Sent: 01 May 2019 11:05
To: Simon Davis <Simon.Davis@arun.gov.uk>
Subject: FW: Y/29/19/DOC Kings Close Yapton - Verification

In relation to the ground contamination aspect, I have now read (amongst other submissions) Ground Management Ltd.'s Verification Report (Phases 1-3) (ref.: G6308-04/03, dated April 2019) and would please request that the following queries are addressed:

TITLE: Verification Sample Location Plan

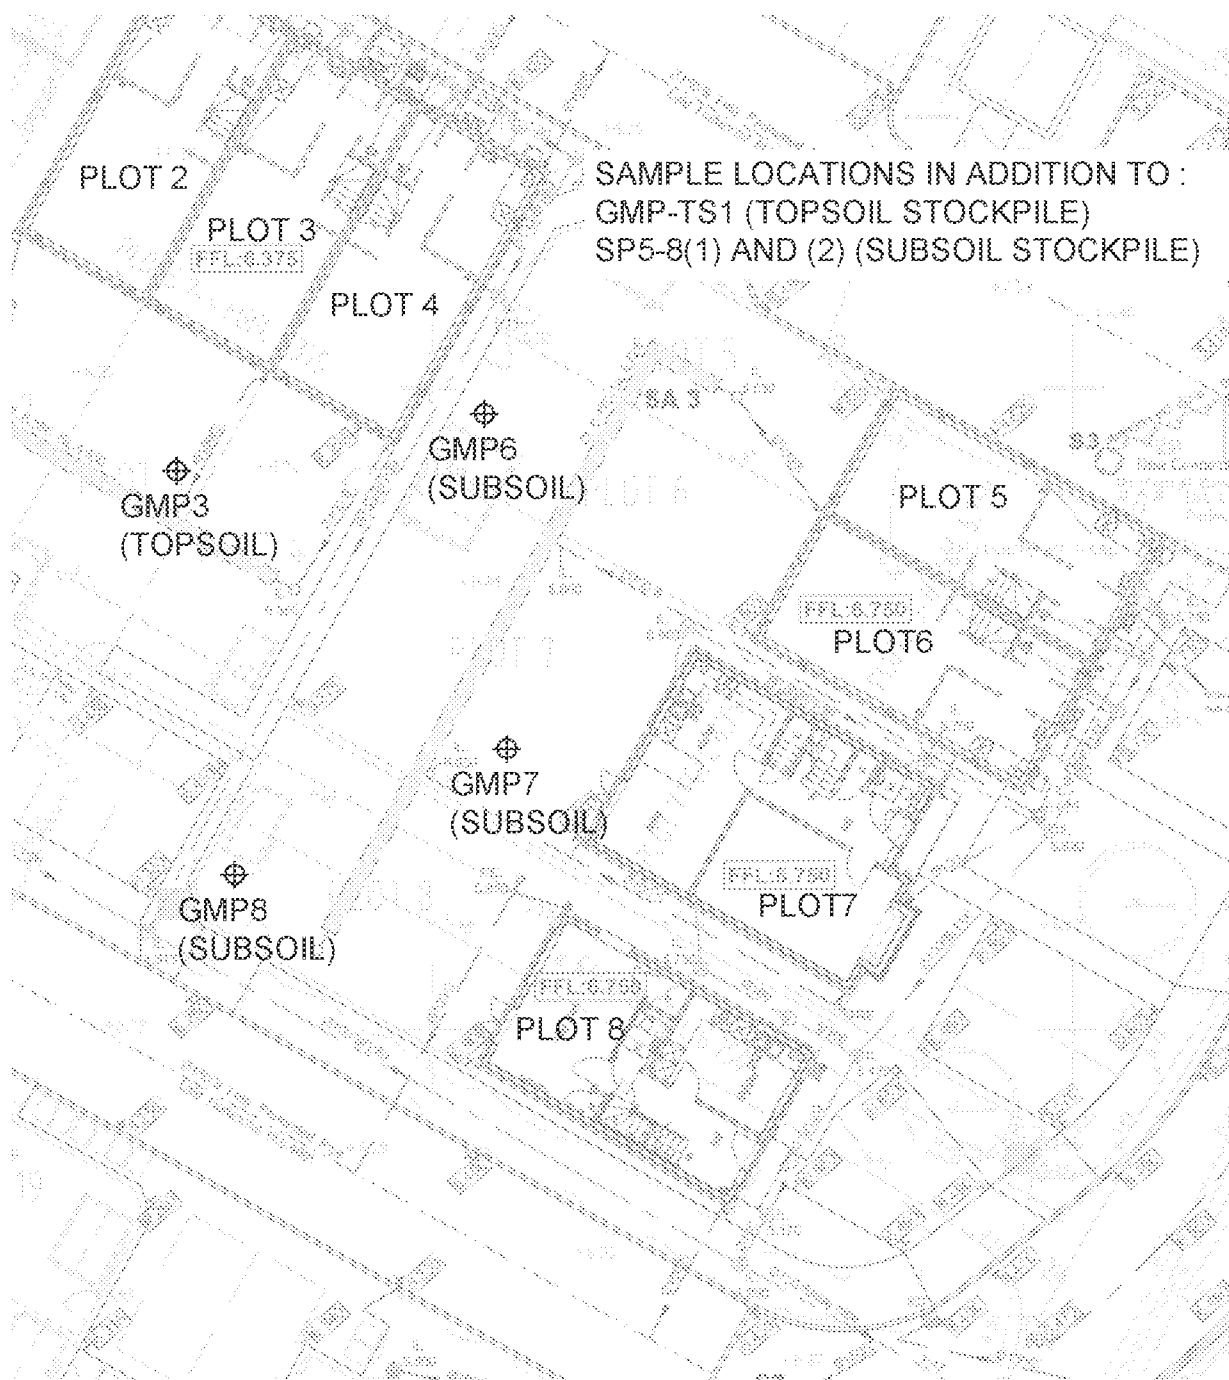
1. since the report was published, has any validation sampling been undertaken for the areas of soft landscaping to the front of plots 5-8?
2. since the report was published, has any validation sampling been undertaken in the area to the north of the site where topsoil placement was to be completed?

1. & 2. The tests carried out on the soils imported to site has focused on the rear garden areas and is equivalent to an overall frequency in the order of 1 suite of tests per 50 cubic metres. There has been no further validation sampling and testing of the relatively small areas in front of plots 5 to 8 or across the north of the site. Provided the imported soils are from the previously validated source, and appear visually consistent, further testing is not considered necessary.
